From: Jacob Halverson <jacob.halverson@mercerisland.gov>
Sent: Thursday, January 11, 2024 1:46 PM
To: marianne@pluspermit.com
Cc: Ruji Ding <ruji.ding@mercerisland.gov>; 'John Byrne' <johnbyrne@groundsupport.com>
Subject: Re: Follow-up Question _ Shoring Outside of ROW Permit 2109-050

From: Jacob Halverson <jacob.halverson@mercerisland.gov>
Sent: Thursday, January 11, 2024 10:43 AM
To: marianne@pluspermit.com; 'John Byrne' <johnbyrne@groundsupport.com>
Cc: Ruji Ding <ruji.ding@mercerisland.gov>
Subject: Re: Follow-up Question _ Shoring Outside of ROW Permit 2109-050

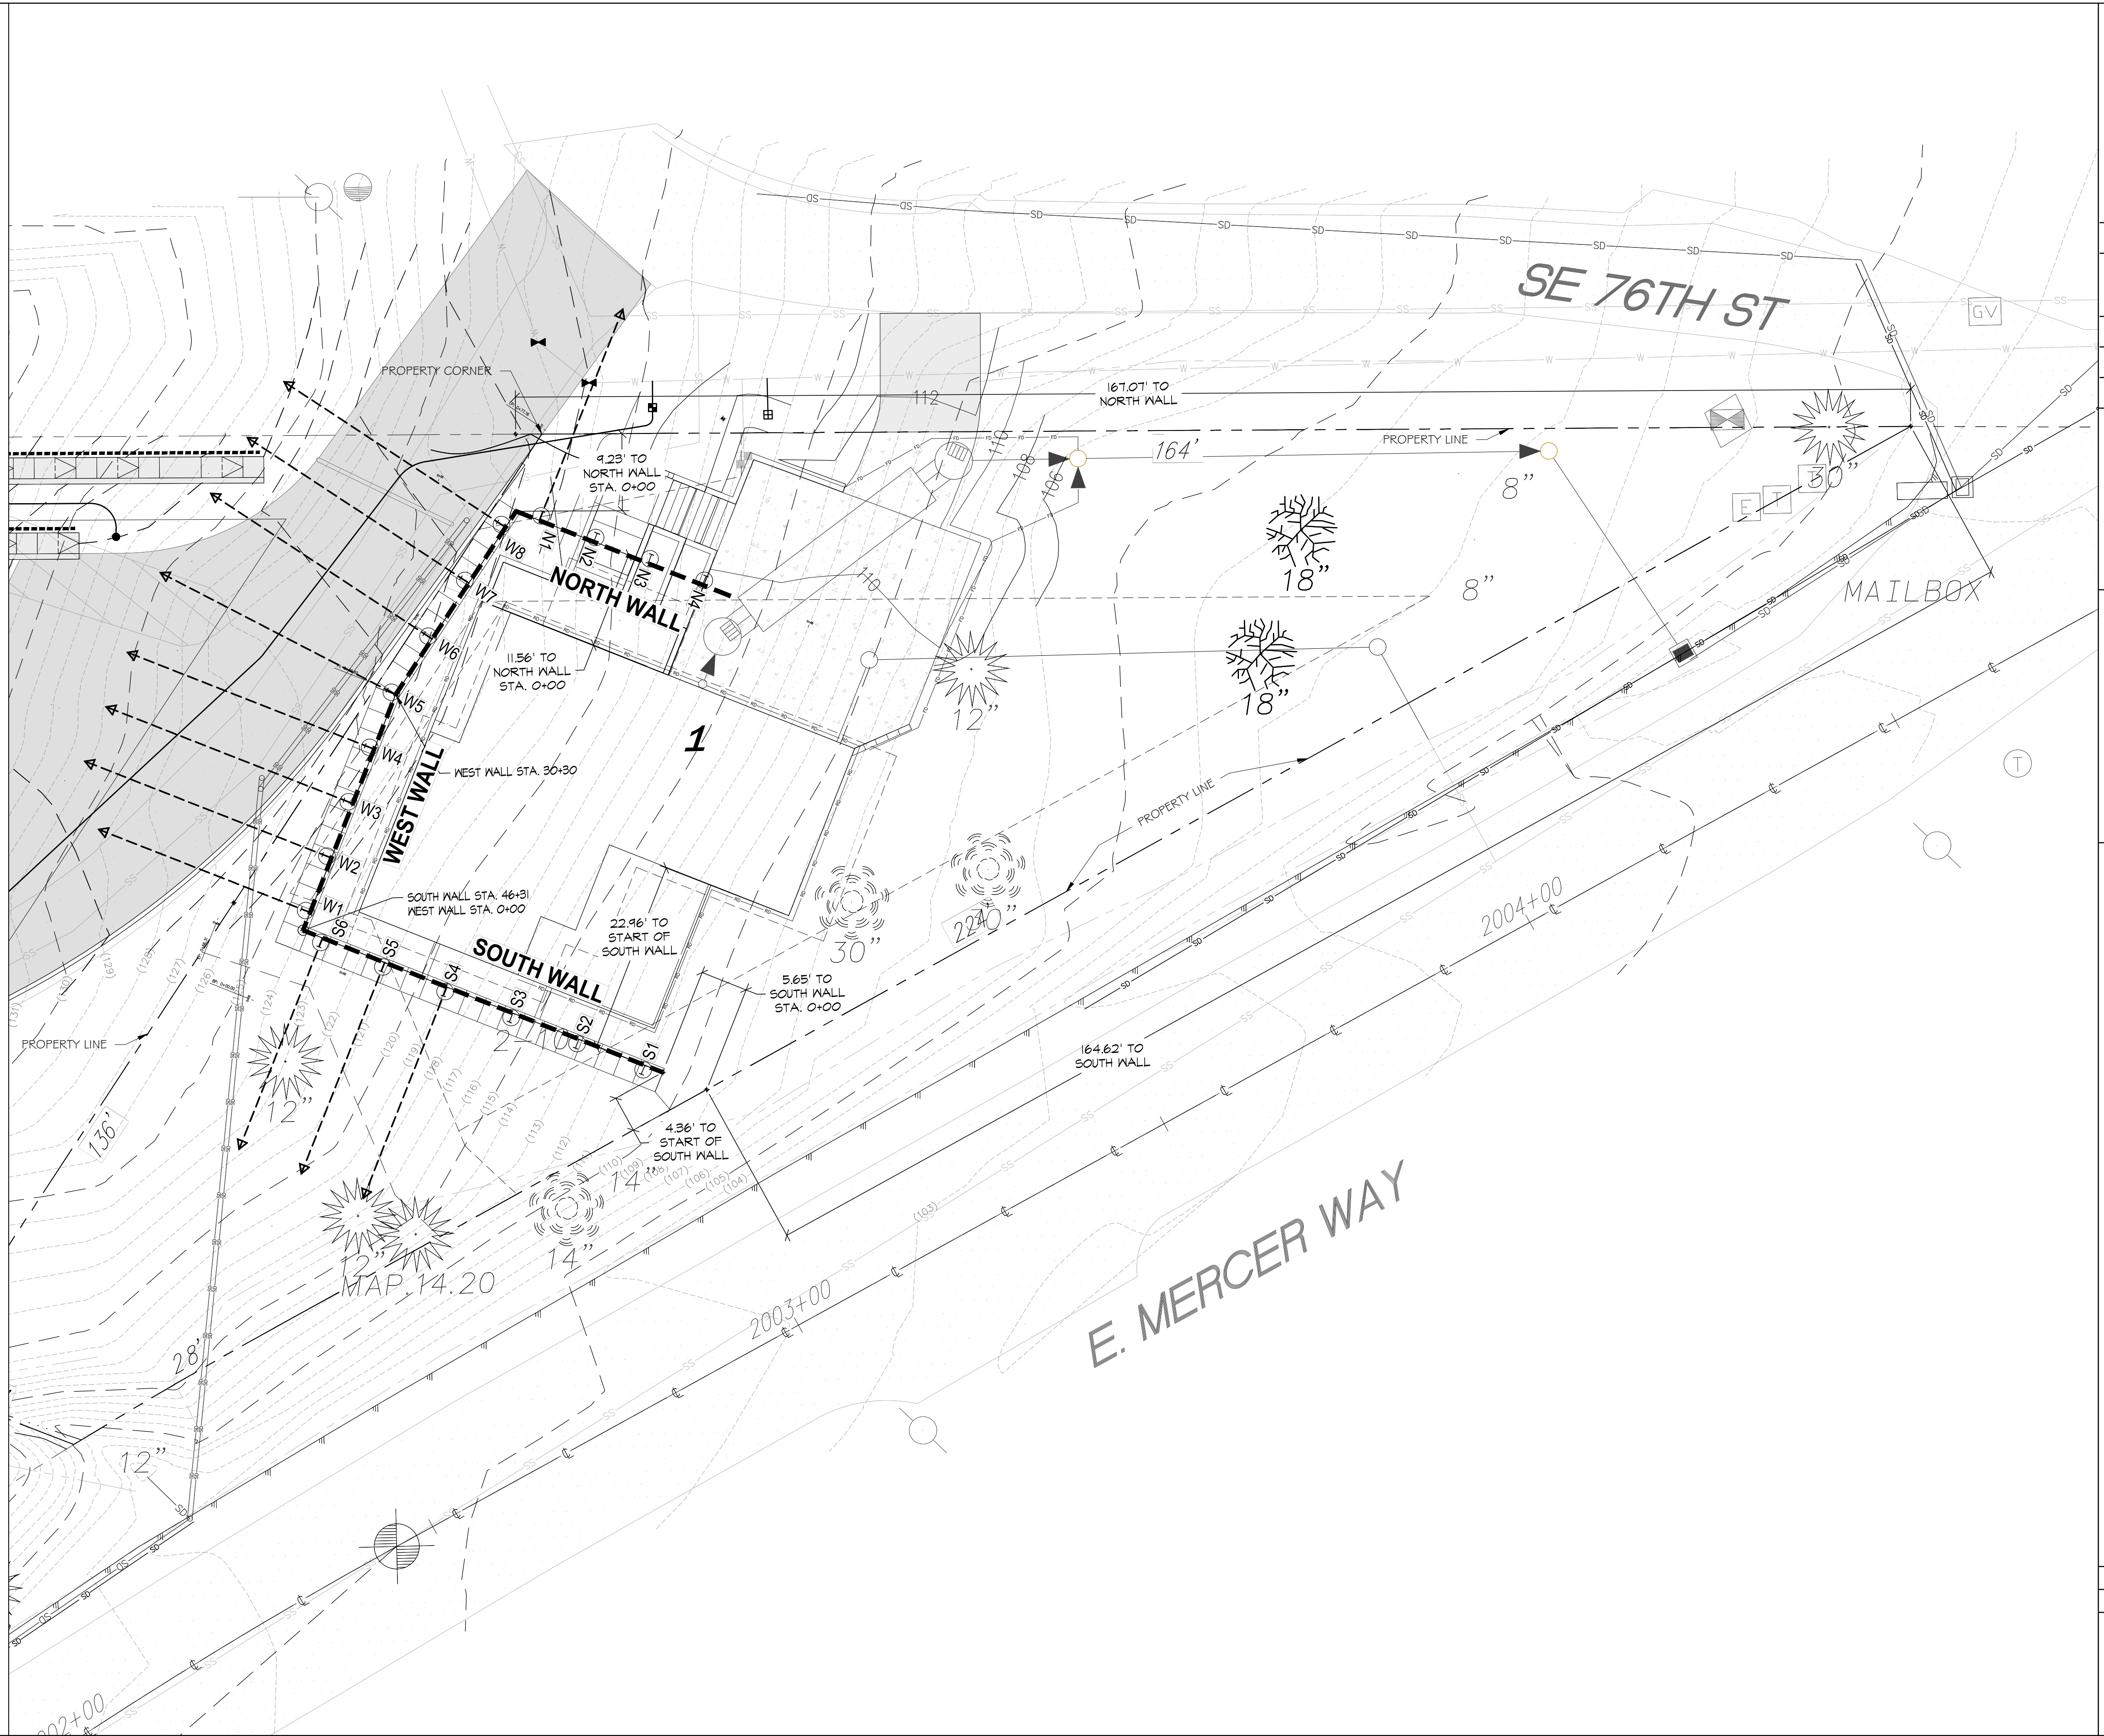
Thanks Ruji, Hi Marianne,
 W7 appeared to extend over the property line.
 According to the calc packet the shoring designer specified 35.6 length of the anchor. At the proposed 25 deg. down angle it would land around 32.5 in length along the horizontal.

This would plant is just outside the property line.

Revising the design to be wholly out of the property line and place a plan note that states anchor will not be placed in the r.o.w. would close out this comment.

We request the reviewer look at the drawings for the planned anchor length, as calculation results are rounded. The planned anchor length is 35 feet and the horizontal projection is therefore 31.7 feet. That is what will actually be installed.

We are planning to shorten this anchor (W7) a little further as we deal with the W8 and N1 anchors as well. The anchor lengths specify a design load and a bond length and that is the direction that the installer needs to follow and demonstrate (re: why the plans should be reviewed instead). When we use a design pullout resistance in our calculations, it is permissible to round the numbers (design loads and bond lengths) in a manner that might require a higher bond strength than used in the calculations. The reason for this is that every anchor is individually tested and so as long as the required bond for that anchor is demonstrated in the field, it matters not what the calculations indicate.

As far as W8 is concerned, we are going to revert to a steep bar anchor (that permits the use of a shorter minimum unbond length) and also use a higher bond strength. This will keep the W8 anchor out of the ROW. For N1, we are going to replace the small anchored soldier pile with a longer and much heavier cantilevered soldier pile. This will provide a design that keeps all anchors out of the ROW.
